CITY OF ALBUQUERQUE

**RE: Maverik Juan Tabo & Cooper
650 Juan Tabo Blvd NE
Permanent C.O. – Not Accepted
Engineer's Stamp Date: 01/14/20
Engineer's Stamp Date: 12/03/19
Hydrology File: K22D059**

Based on the Certification received 01/14/20 and site visit on 01/17/20, this certification is not approved in support of Permanent Release of Occupancy by Hydrology. The following comments need to be addressed for approval of the above referenced project:

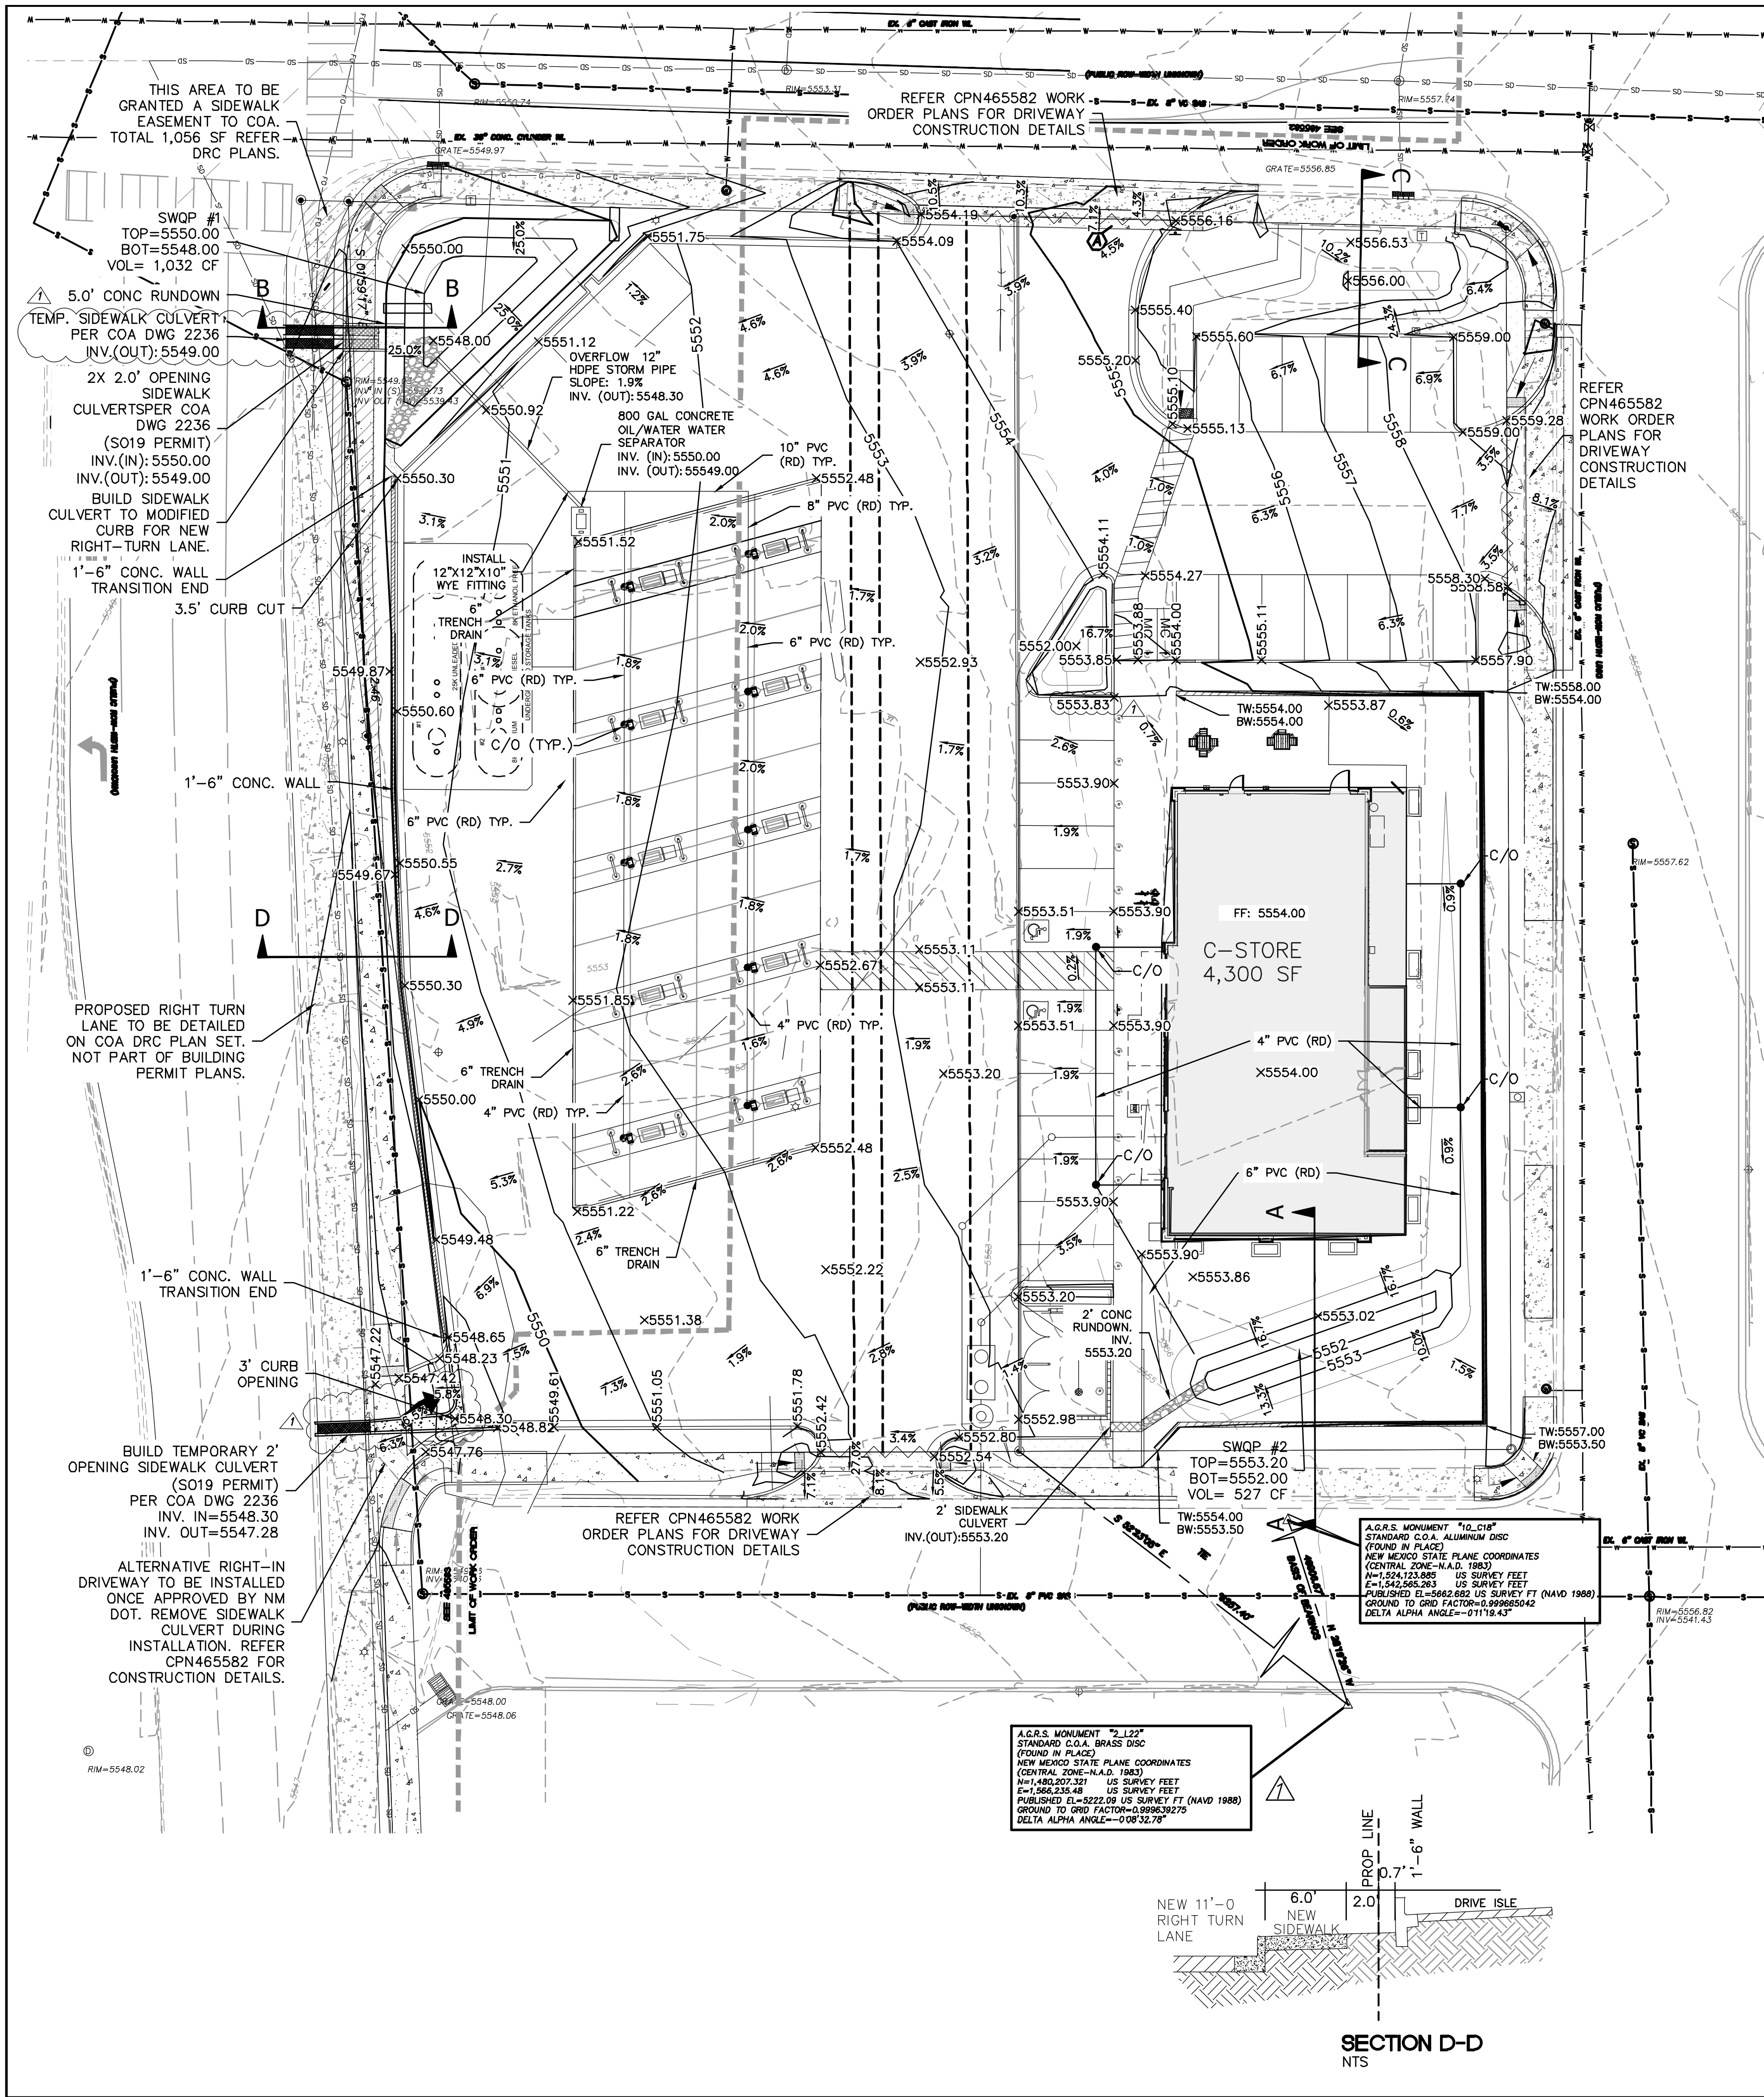
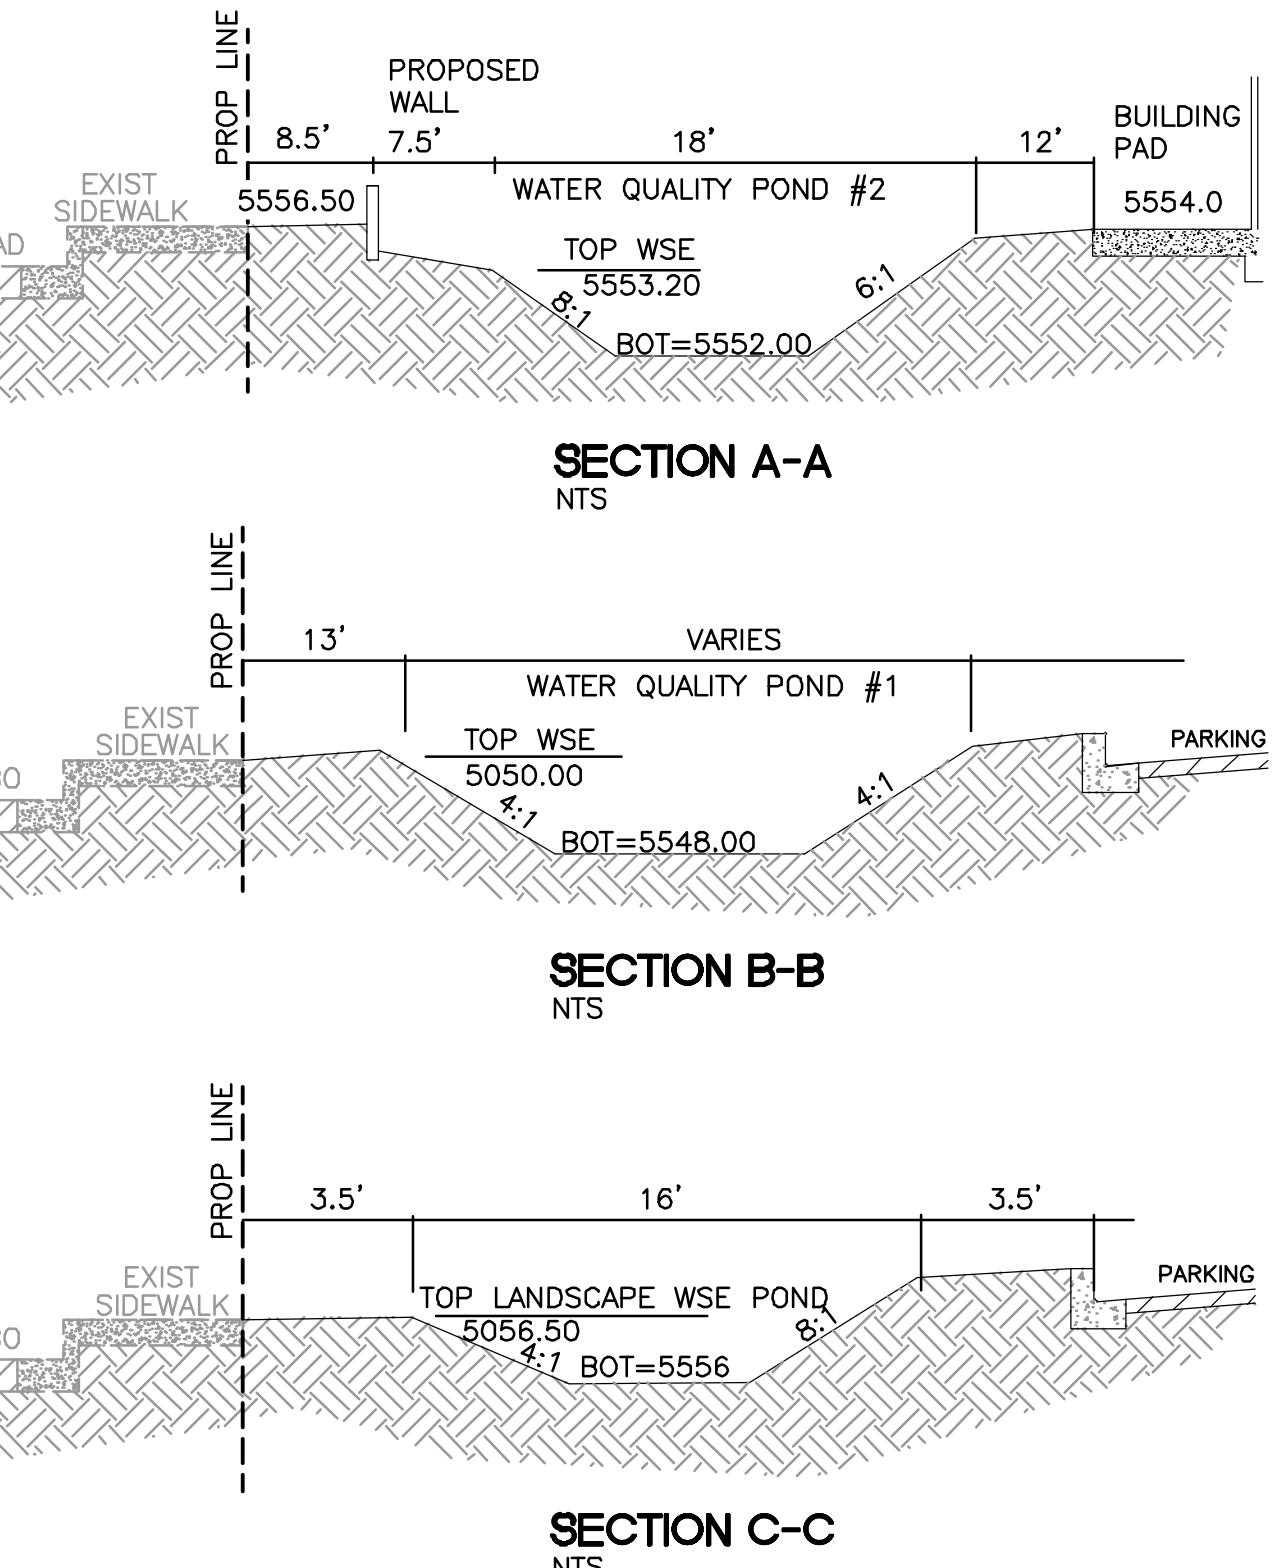
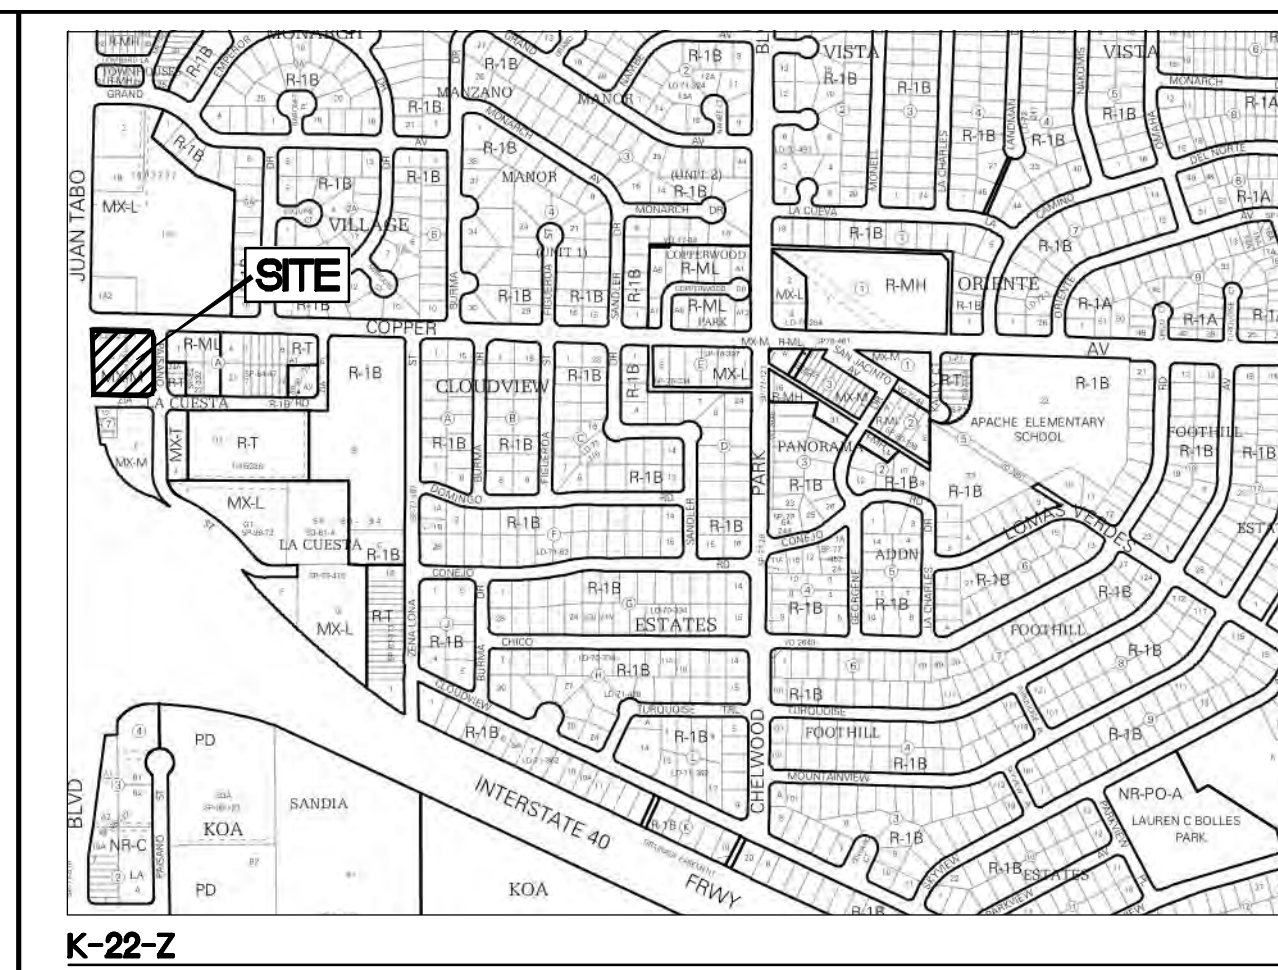
2. Please place the steel for the interior sidewalk culvert behind the trash enclosure. See Photo below.
